Your 3/2020/0145
ref
Our ref 23rd March 2020
Date

Application Land adj. 9 Chatburn Old Road, Chatburn
Proposal: Erect single detached dwelling

Director of Highways and Transport
Lancashire County Council

site plan as proposed

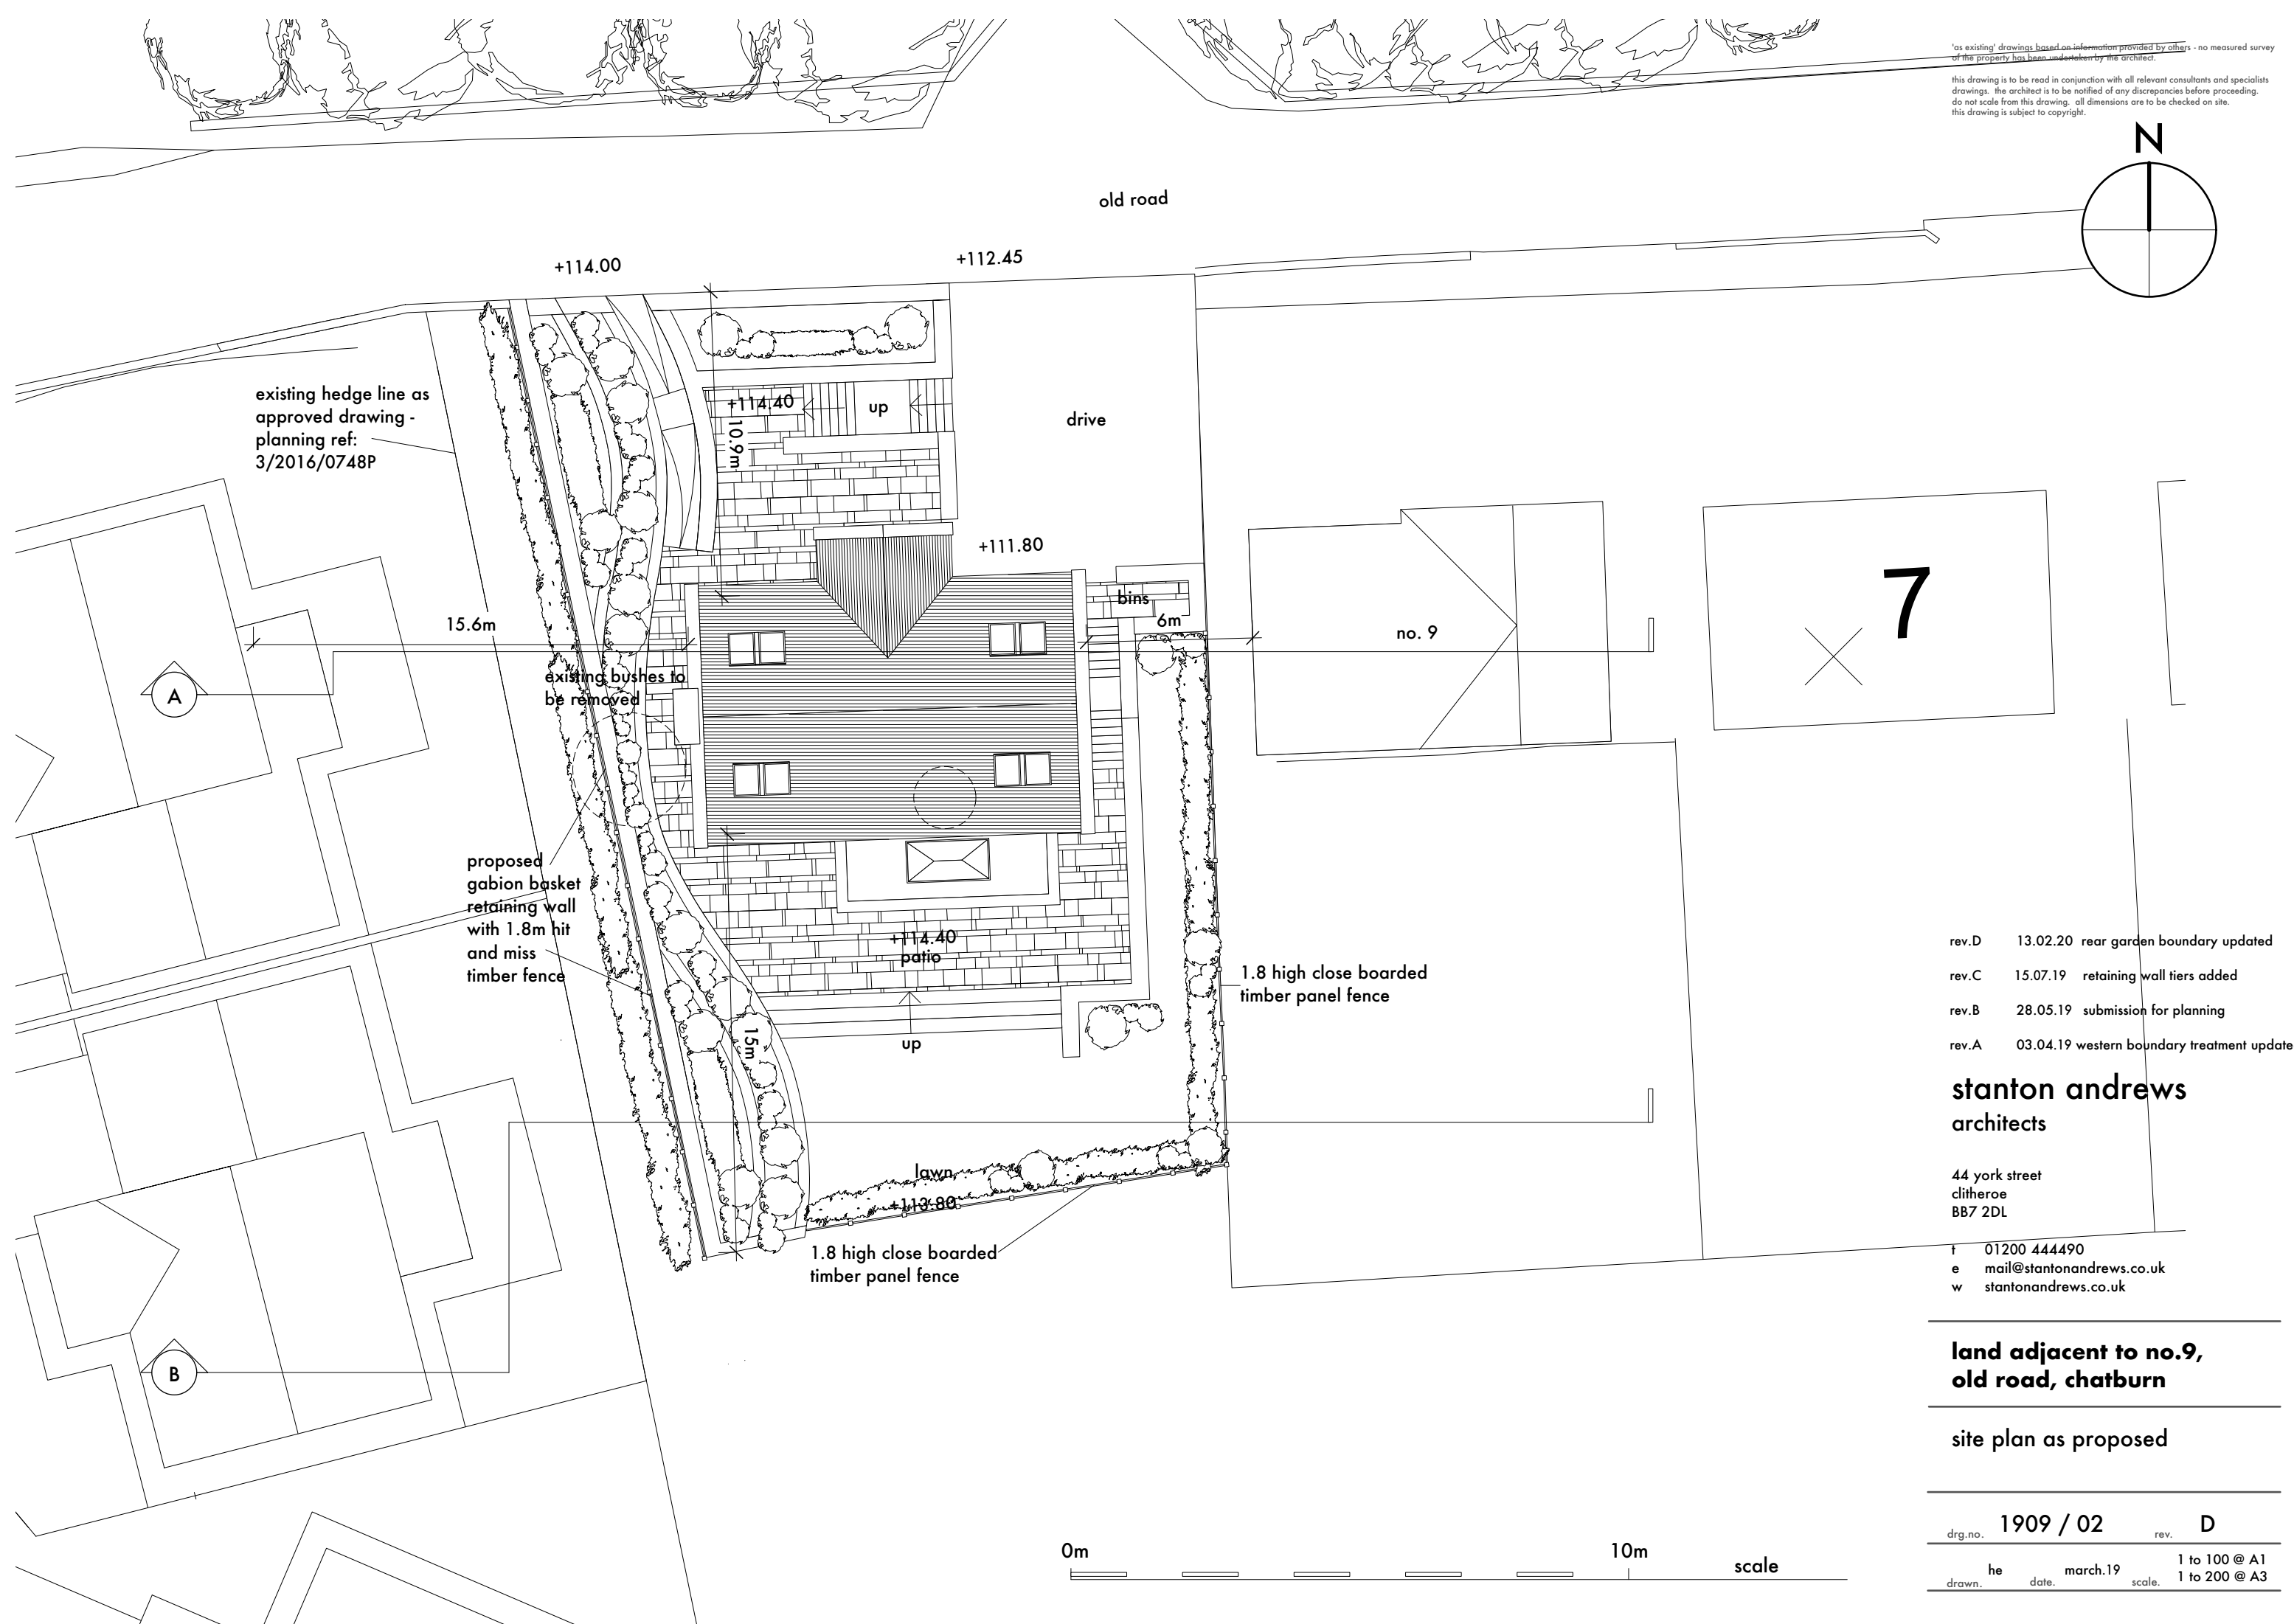
The proposal is for a single detached 5 bed dwelling to be erected on land to the west of No. 9 Chatburn Old Road. The proposal has been the subject of a previous planning application (3/2019/0498) to which the highway authority raised no objection subject to clarification of the verge treatment to the frontage onto Chatburn Old Road. This issue has yet to be clarified but to reiterate the comments to the previous application, I would raise no objection but I would need further clarification regarding the proposal for the land to the front of the retaining wall fronting Chatburn Old Road . I would need to be assured that the treatment of this area, vegetation or otherwise will not impinge on the sightlines available when exiting the drive.
